Consultation Response from KC Highways Development Management		
2025/93225 The Richardson Arms, 684 Bradford Road, Oakenshaw, BD12 7EN		
Alterations to convert former public house to 5 flats and erection of 4 dwellings with associated works.		
Date Responded: 23/04/26	Responding Officer: M Zenner	Responding Ref: 7-12NW/16

RECOMMENDATION: Further information and amendments are required.

## **Appendix 5: Proposed Development Plan**

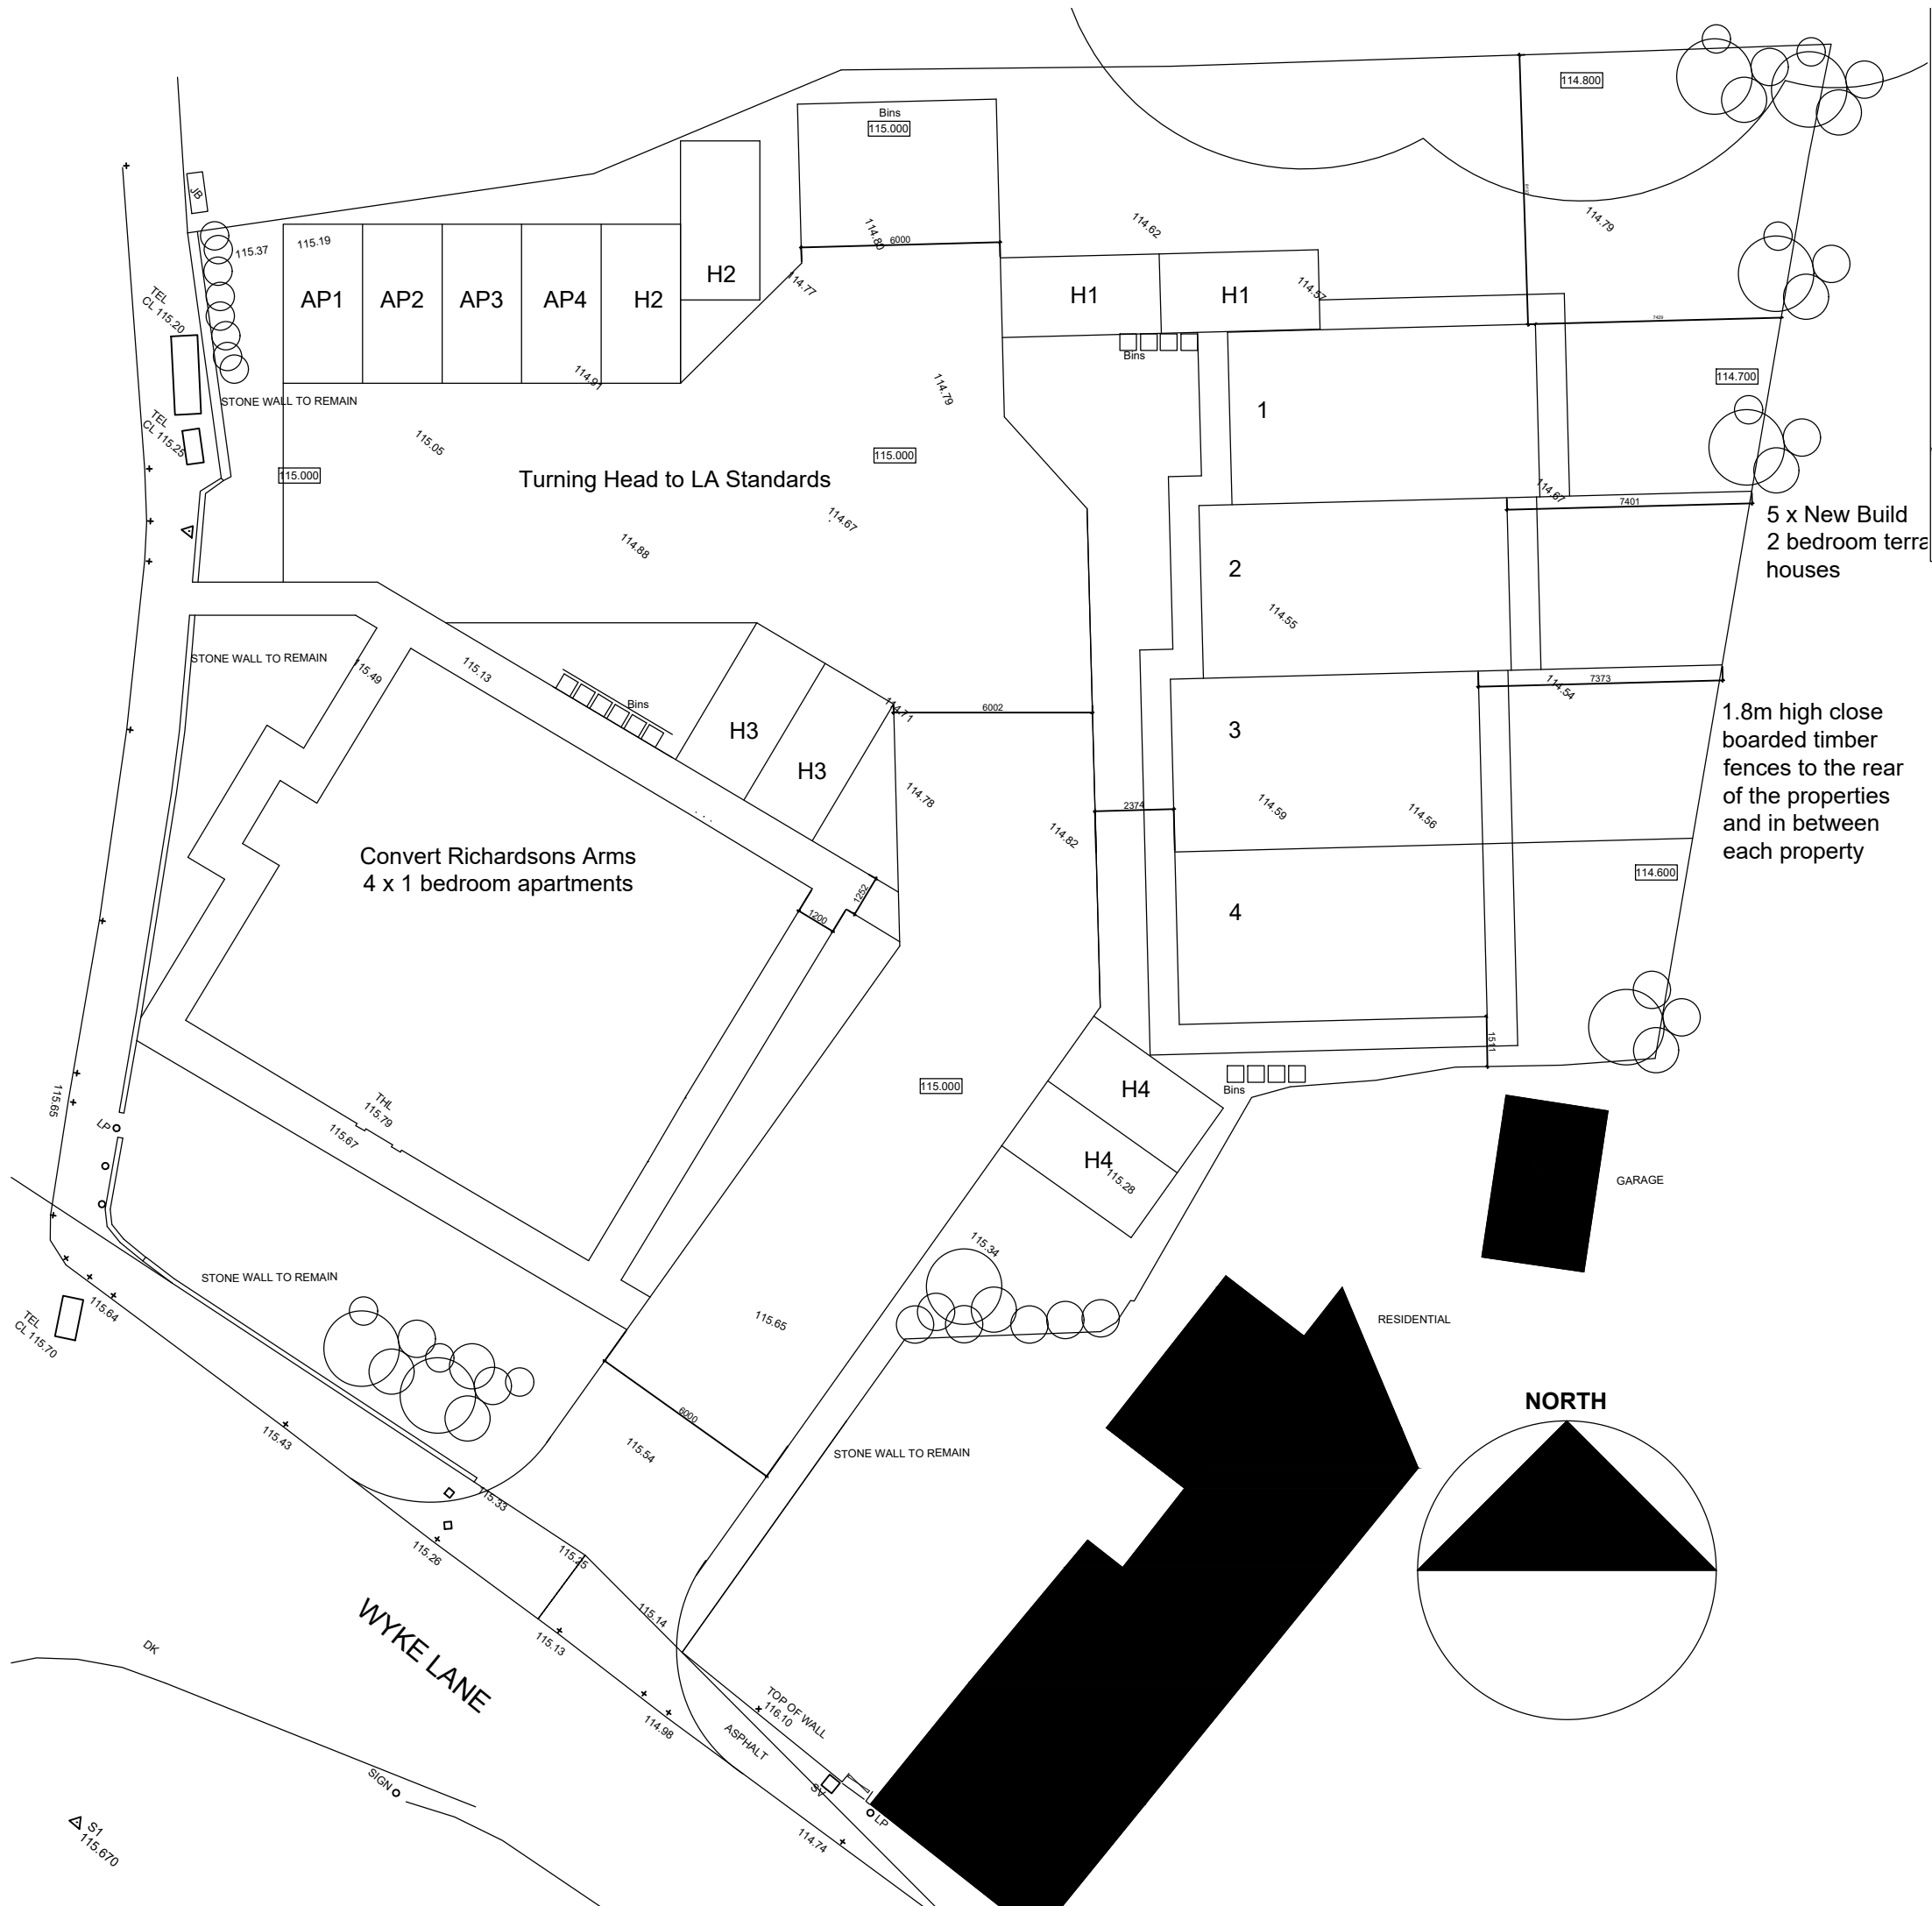
The site layout plan details the provision of one car parking space per apartment and two per dwelling house but no visitor parking spaces are detailed within the site and therefore this shortfall has the potential to result in overflow parking on Wyke Lane which could impede access to the site and access to the neighbouring properties.

The proposed driveway for House 1 (H1) should be increased in length to 10m and widened to 3.2m to allow pedestrian access alongside the proposed parking spaces.

An area for bins is shown adjacent to House 1 but it is unclear if the access road is proposed to be adopted or if it can accommodate a standard RCV. Bins are also shown on the northern side of the pub building and adjacent to House number 4.

It does not appear that there is an adequately sized turning circle available within the site to allow a standard Kirklees RCV to access and egress the site. However, in the LHA's view there is the potential for the provision of an approximately 10m stretch of the proposed access road to be designed to comply with the Kirklees Highway Adoption standards to help create a turning head on Wyke Lane that could provide space for a refuse vehicles to turn.
